Appeal Decision

Appeal Ref: APP/R5510/W/21/3282716

2 Midcroft, Ruislip HA4 8ES

- The appeal is made under section 78 of the Town and Country Planning Act 1990 against a refusal to grant planning permission.
- The appeal is made by Mr I Deooray against the decision of London Borough of Hillingdon.
- The application Ref 4918/APP/2021/1103, dated 17 March 2021, was refused by notice dated 16 July 2021.
- The development proposed is the erection of a part 3 storey, part 4 storey residential building comprising 9 flats with associated access and landscaping following demolition of existing petrol filling station / car wash.

ACCESS TO THE REAR  
PROPERTIES TO BE  
MAINTAINED AS BEFORE

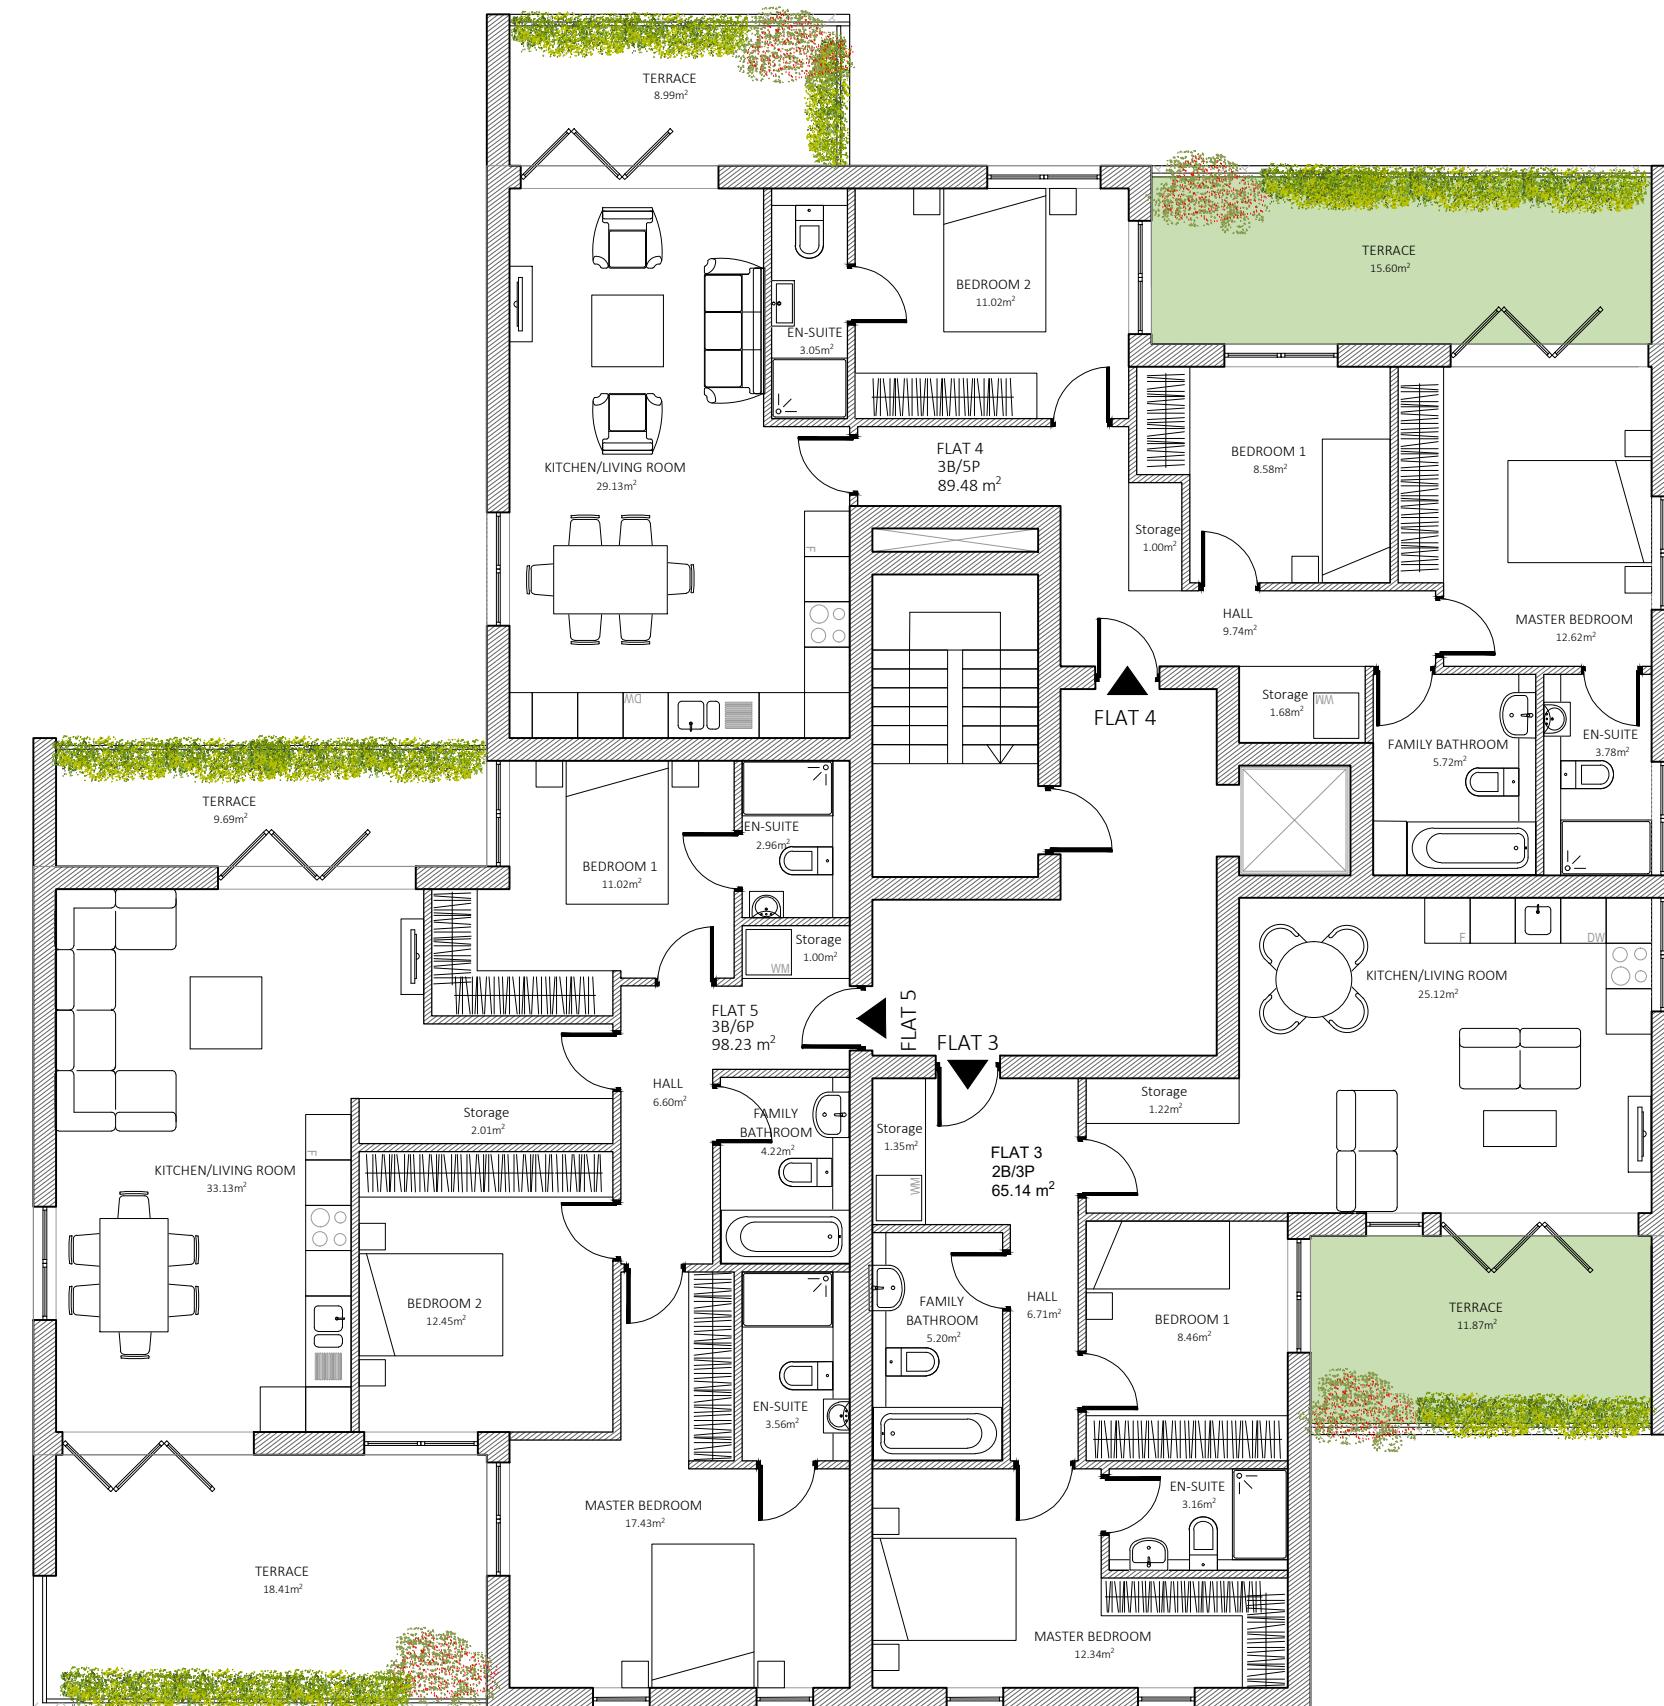
19. With respect to the latter scenario, the proposed plans demonstrate how access to the spaces to JH would be maintained and how new parking spaces would be provided to serve the appeal development. This arrangement met with no objection from the Highway Authority. Larger delivery vehicles would no longer be able to enter the appeal site, but if a legal right for such vehicles to do so did exist then that right would seemingly serve to prevent the development from taking place at all in its current proposed form. That would be a matter for the appellant to establish and address.

PROPOSED FRONT ELEVATION
SCALE 1:100

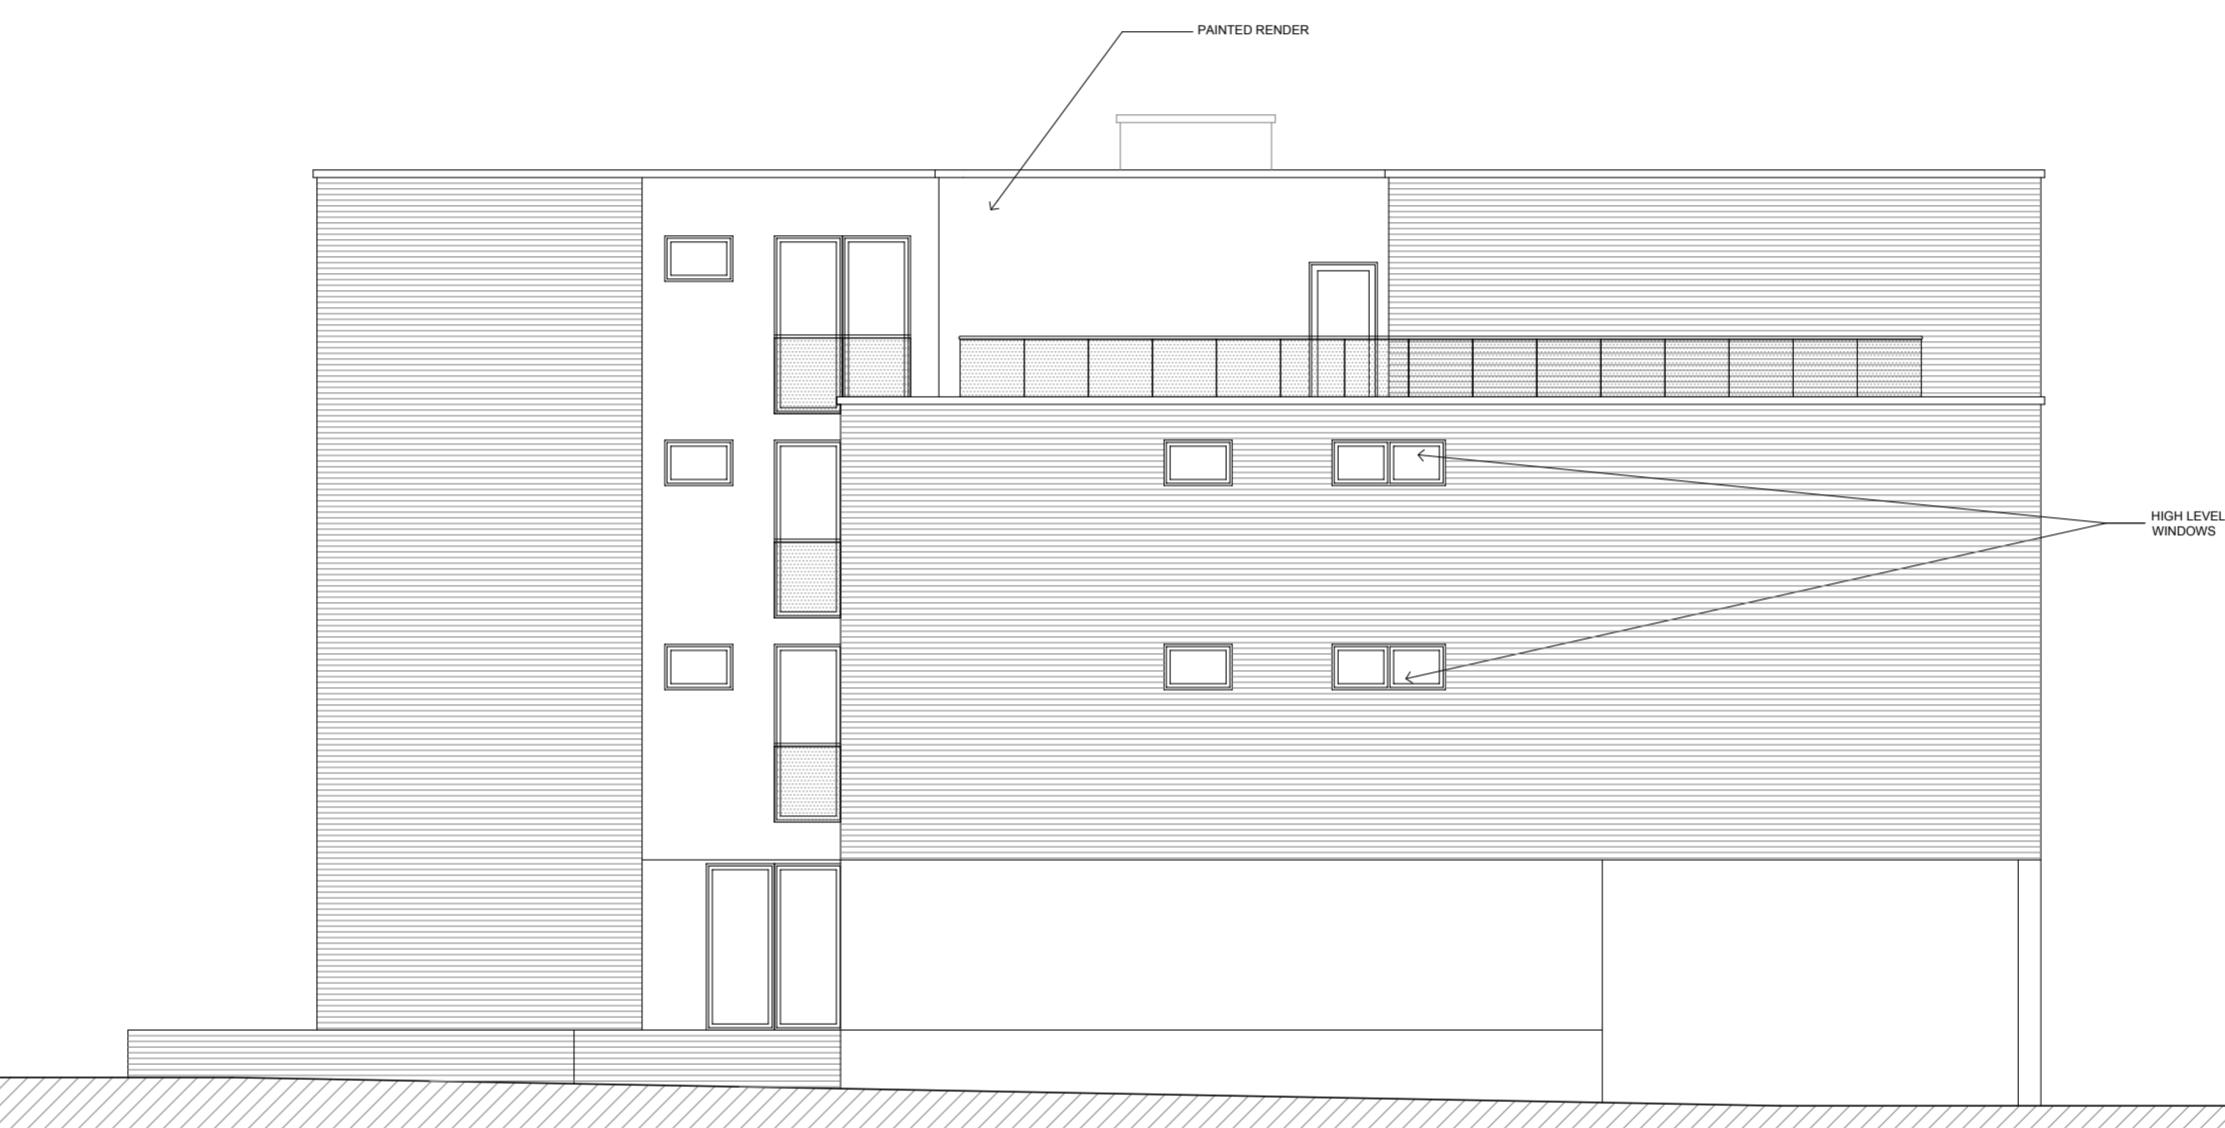
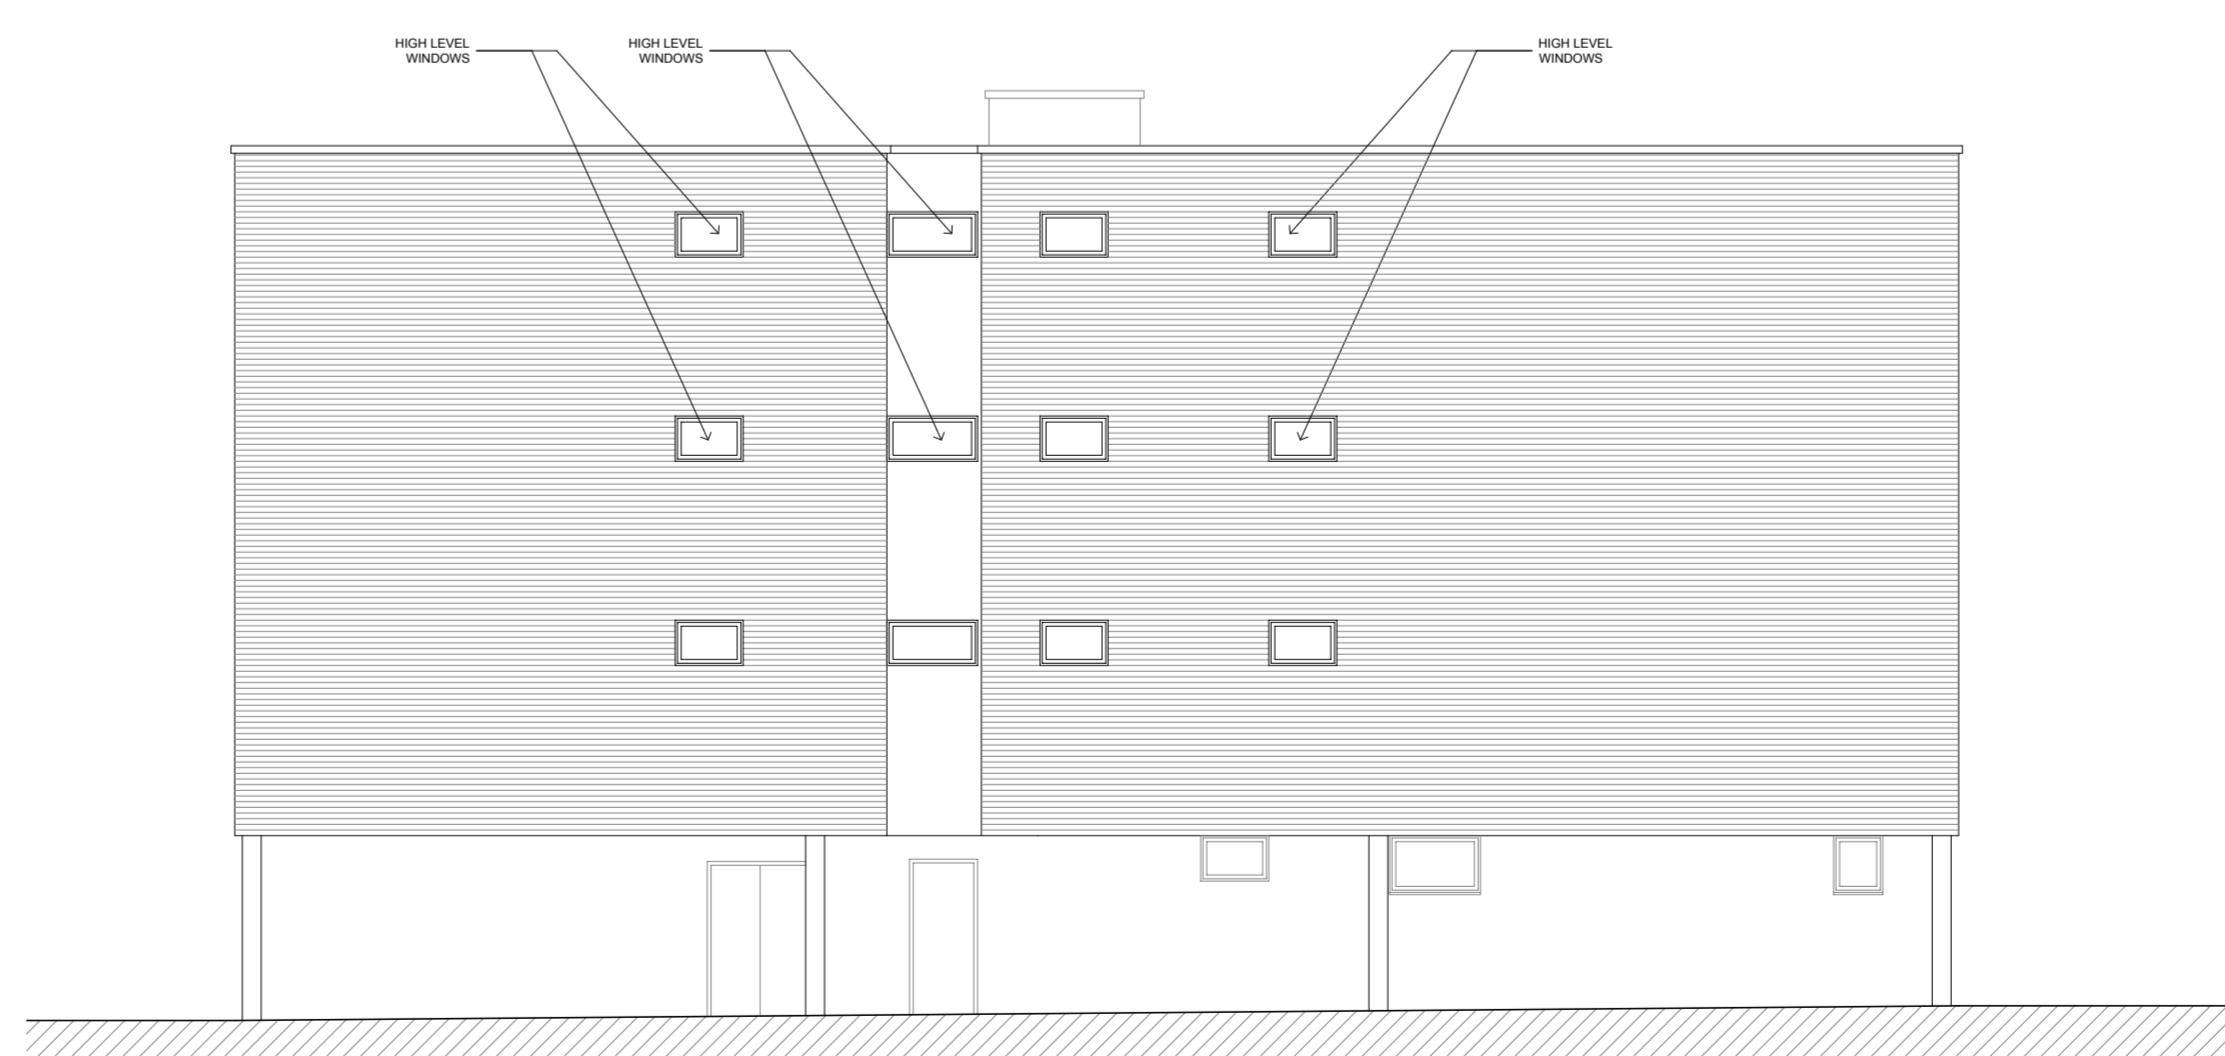
8. The general scale of the proposal would be appropriate, as although it would have a greater massing and height than the adjacent dwellinghouses there would be a separation formed by the intervening access road and pedestrian access to the nearby area of public open space. However, the proposed design would incorporate an overly large and bulky front gable which by reason of its size and prominence would be a visually dominant and incongruous feature in the street scene. There would also be visual incongruity caused by the different setbacks to either side of this gable. No updated information has been provided to explain the design ethos that has been adopted on the amended proposal or to demonstrate how it has been redesigned to be visually sensitive to its surroundings and the CA.

9. Due to its design and overall appearance, the proposal would fail to visually integrate into the street scene and the CA in an acceptable manner and it would not represent good design that would reflect the context of its surroundings. It would as a result cause harm to the character and appearance of both the area and the CA. Given the nature of the proposed development and that the harm would be localised, I consider that less than substantial harm to the CA would arise. This being the case, it is necessary to weigh the public benefits of the proposal against the harm that would arise to the CA, in accordance with Paragraph 202 of the National Planning Policy Framework (The Framework).
